****** CLARIFICATION LETTER ******

PROJECT #: 21-2816-B

DATE: June 6, 2023

PLANS REF: Plan 02 (The Holly) by South Designs

S-3.1

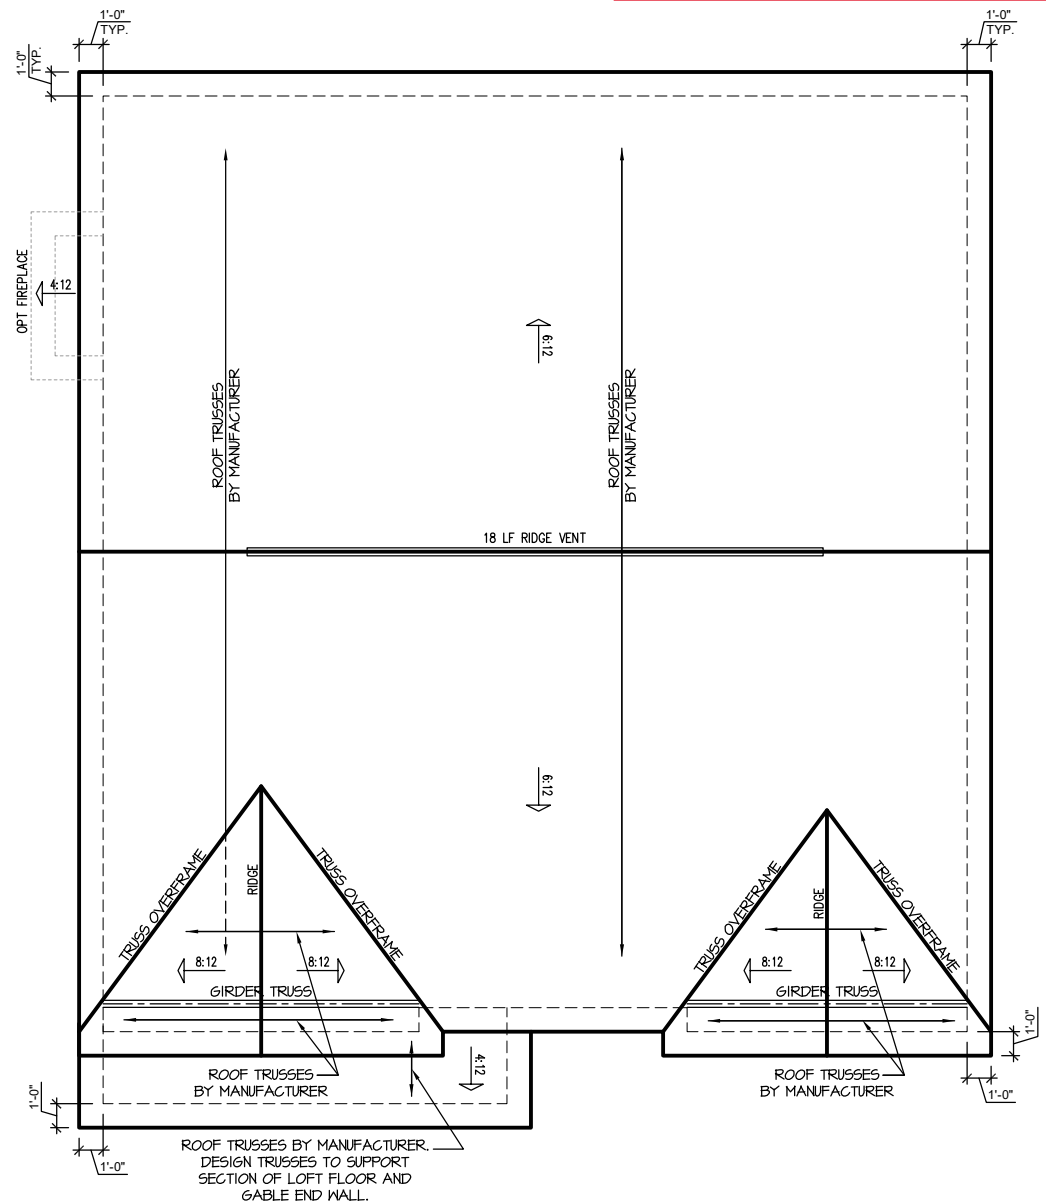
Garage LVL Clarification with Floor Trusses: Sheet S-3.1 of the Craftsman and Georgian elevations shows a 1.75x14 LVL at the edge of the cantilevered section of floor at the front of the garage. Please note that when floor trusses are used a truss (designed by the truss manufacturer) may be installed in place of the noted 1.75x14 LVL.
